Planning consultation: Erection of a 60.7m (to tip) single wind turbine

Location: Land north of Huntroyde Home Farm, Huntroyde West, Whins Lane, Simonstone.

We have a number of concerns about the submitted Landscape and Visual Impact Assessment (LVIA) that are set out below:

project title
figure title
figure reference
scale
date
N160: Huntroyde
Viewpoint 1: Trapp Lane, Whittle Hill
N160-GR-LVIA-013
1:25,000 @ A3
February 2013

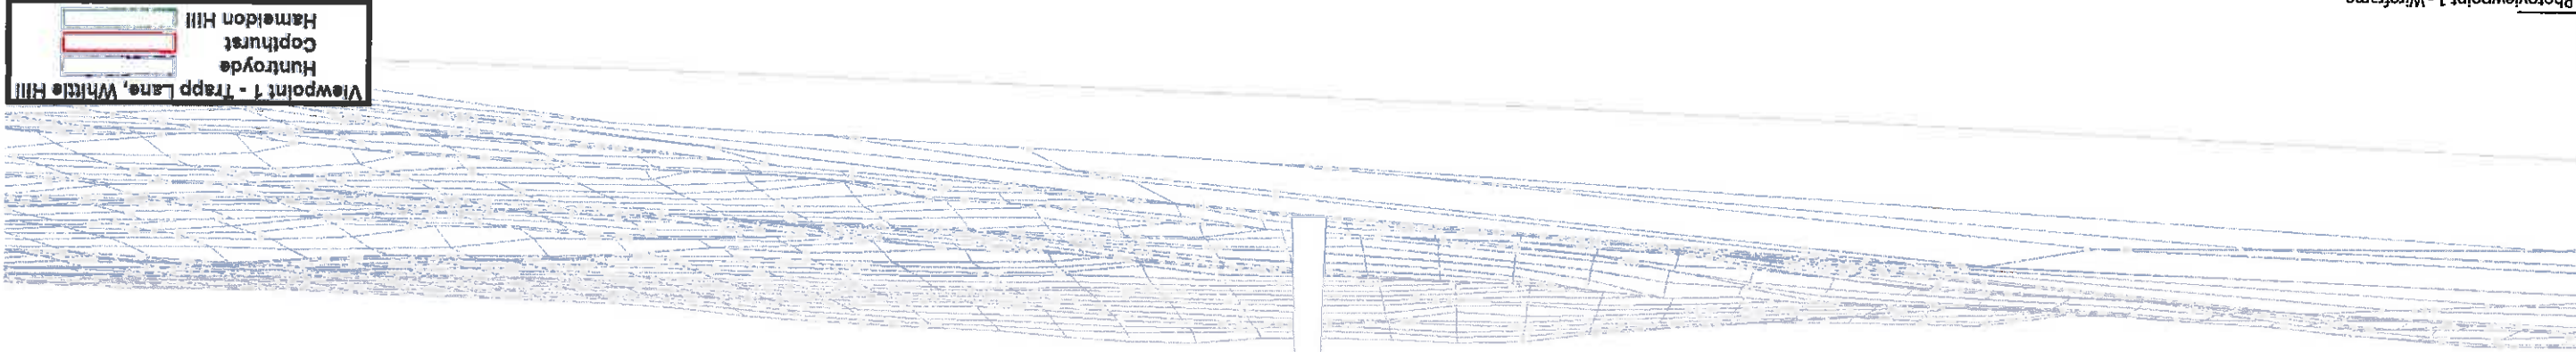
- Viewpoint 1 could have helpfully been angled slightly differently so that it was clear that the proposed Copthurst turbine (Pendle – 13/13/0135P) would also be viewed at this location, in addition to Viewpoint 3. However, we note that the 'panorama' photograph does pick this up.
- The viewpoint location map and the ZTV maps do not show the AONB boundary; we believe its inclusion would help to better understand the significance of the information illustrated.

- Please note that pages 29 and 30 of Volume 1 of the LVIA are missing from the website. These pages will describe the assessment and overall conclusion of significance for Viewpoint 1.
- We disagree with the assessment that the magnitude of change at VP3 is low and consider it to be 'medium' – 'some change in the view that is clearly visible in the view and forms an important but not defining element in the view' (Table A-5).

project title	N160: Huntroyde
figure title	Viewpoint 2: Nick of Pendle,
figure reference	Clitheroe Road
scale	N160-GR-LVIA-015
date	February 2013

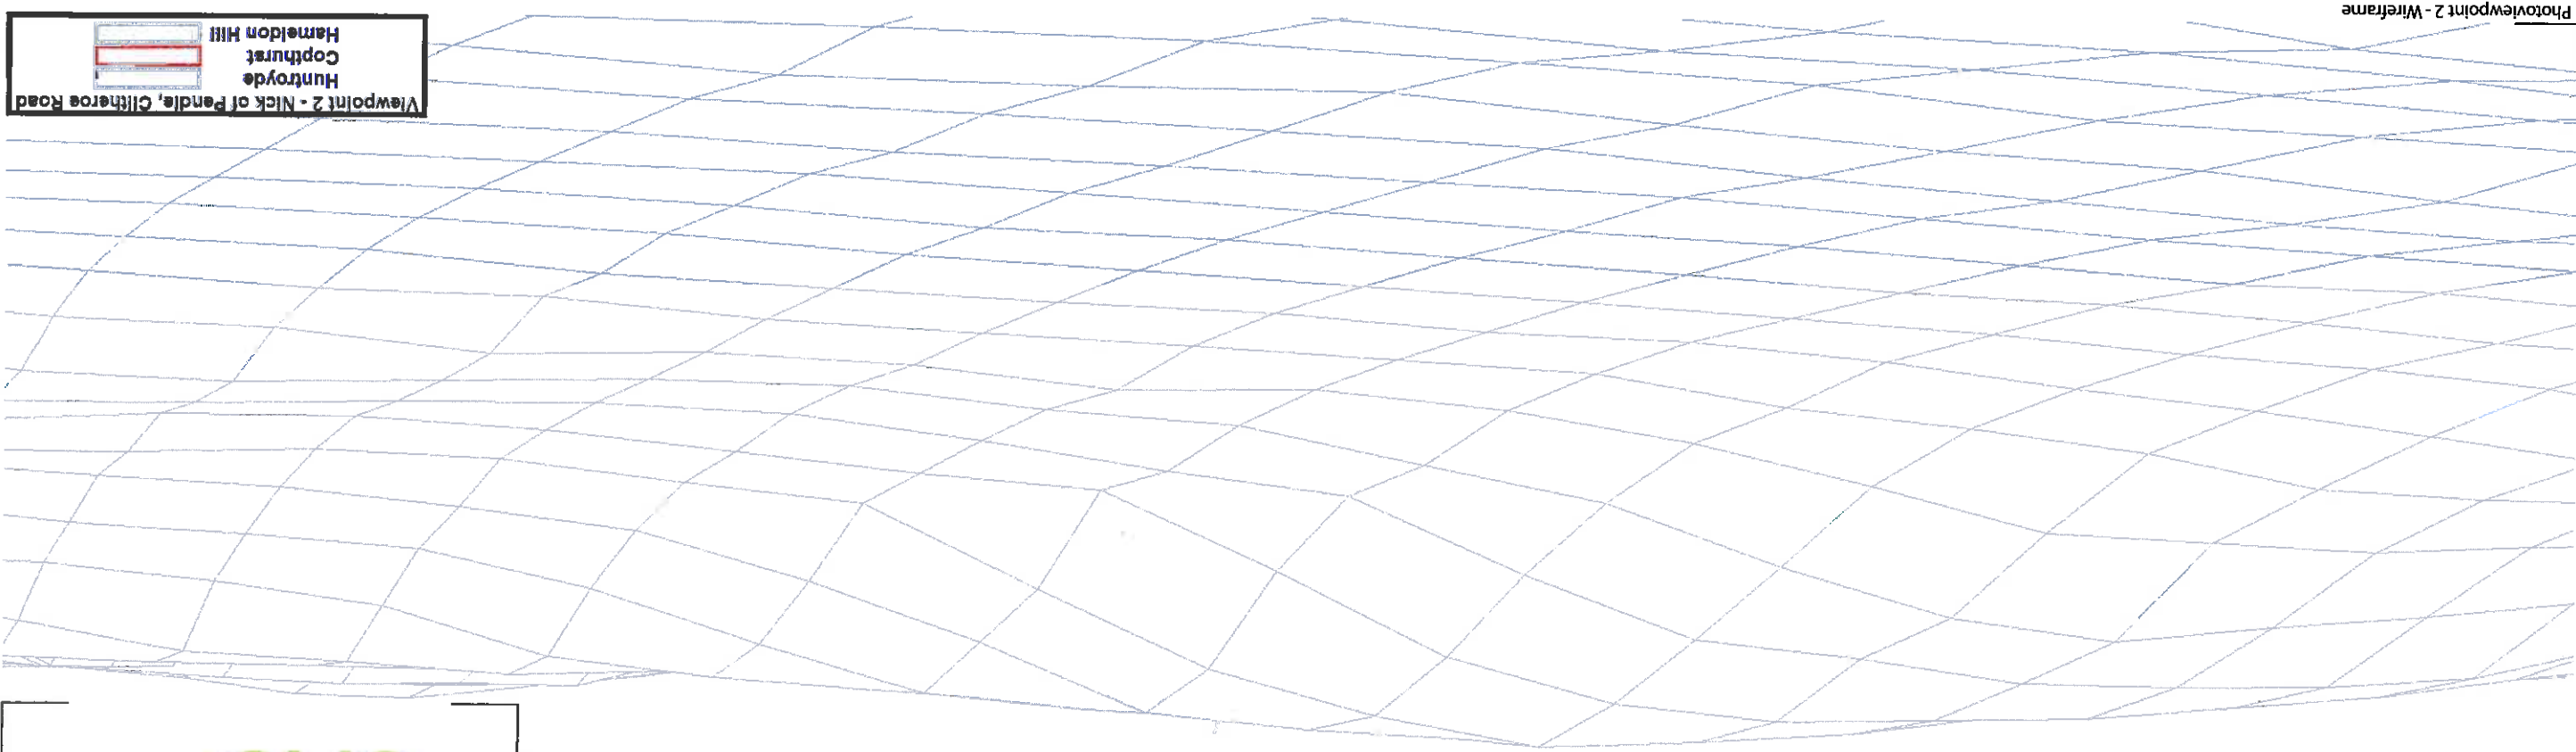
Viewpoint 2 is the most northerly location but appears to sit outside the areas of potential visibility; consequently the photomontage does not show the hub or blades of the turbine at all. What was the reasoning for using this VP when more appropriate locations appear to have been overlooked? **How much more of the turbine would be seen from viewpoints further upslope?**

Viewpoint 3 - Stump Hall, Stumphall Road
Huntroyde
Copthurst
Hameldon Hill

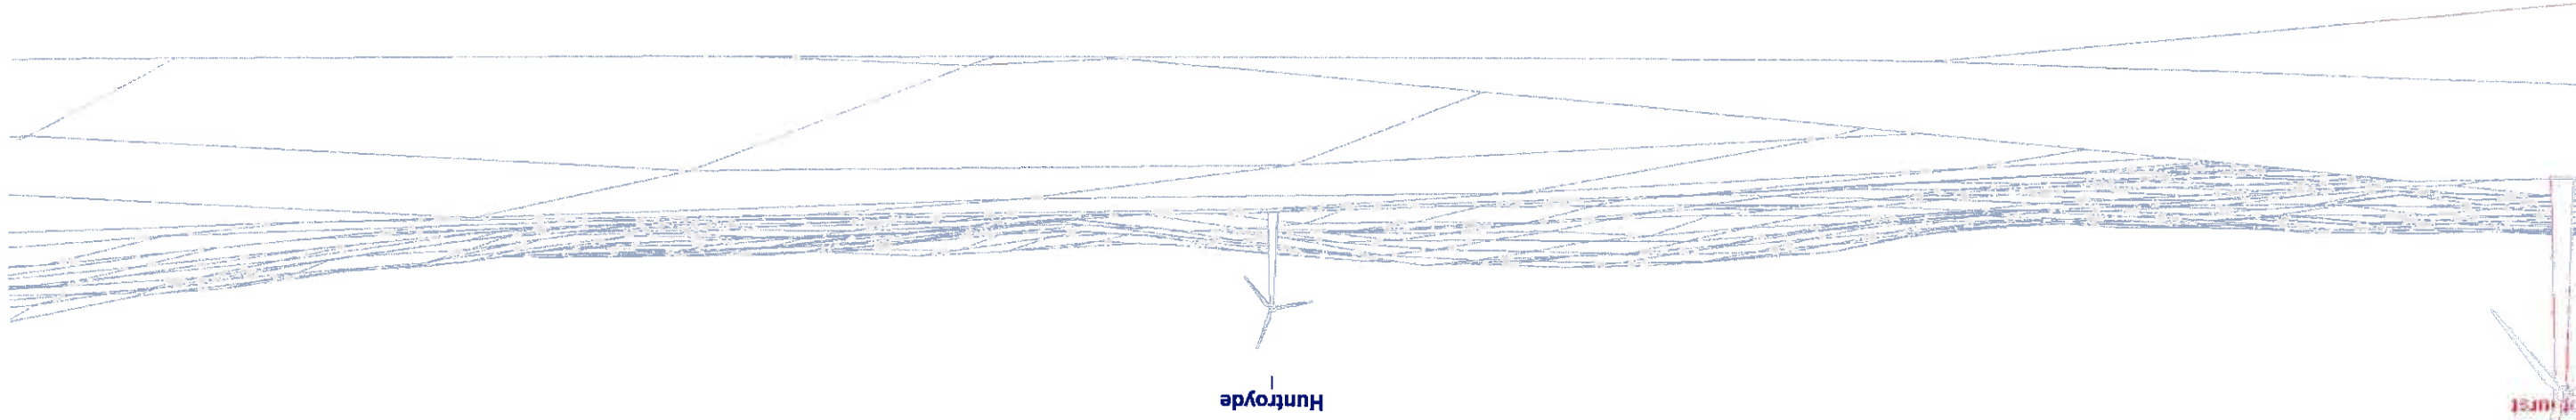
Consequently the impact significance of the proposal at this location is 'moderate' (Table A-6) for footpath and minor road users, which may be regarded as a significant effect in terms of the Environmental Impact Assessment Regulations 2011³.

project title	N160: Huntroyde
figure title	Viewpoint 5: Padiham, A6068 Barrowford Road
figure reference	N160-GR-LVIA-021
scale	1:25,000 @ A3
date	February 2013

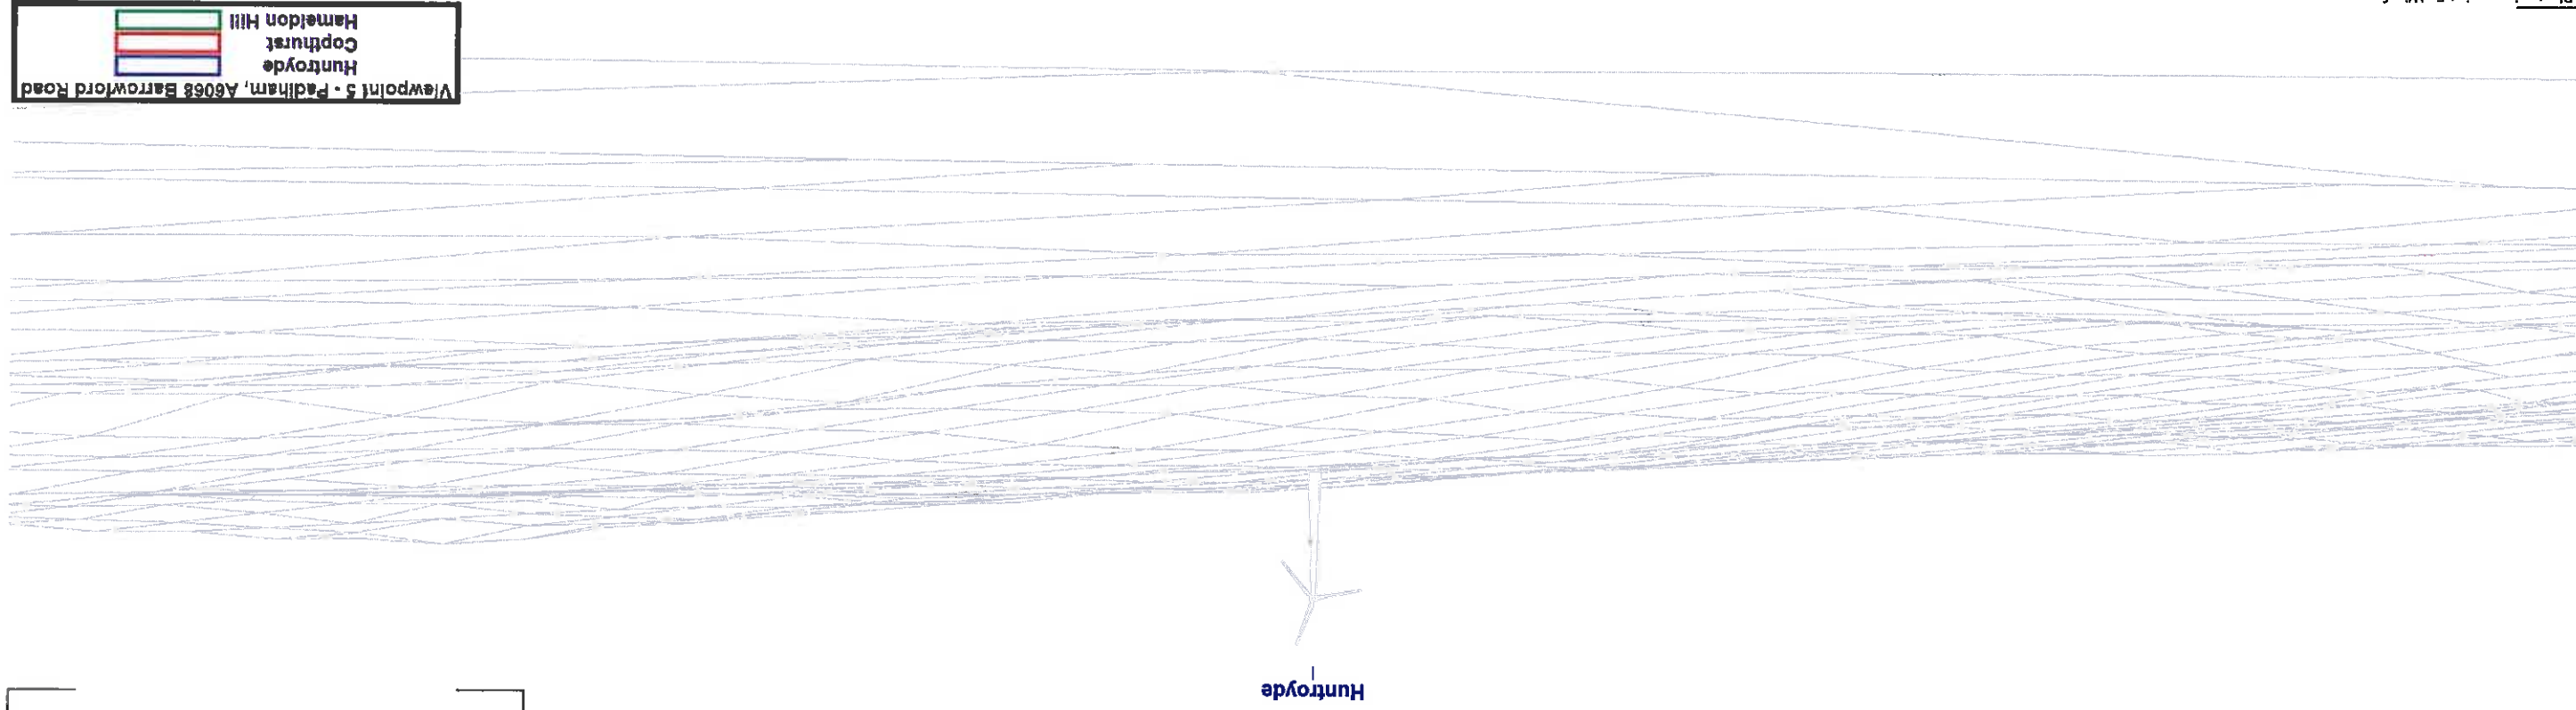
- We note that the LVIA concludes 'moderate' significance for visual impact on footpath users at Viewpoint 5, and also cumulatively with the proposed Copthurst turbine, with an overall determination of 'not significant' in terms of the EIA Regulations.

The location of Viewpoint 5 has also been used in the Copthurst turbine's LVIA and we considered, in our response to Pendle Council, that the magnitude of change was high thus making a 'substantial' level of impact significance. We noted that this would be regarded as a significant effect in terms of the Environmental Impact Assessment Regulations 2011³ in our response.

Consequently, we are concerned that the cumulative impact significance of both turbines might be underestimated at this location.
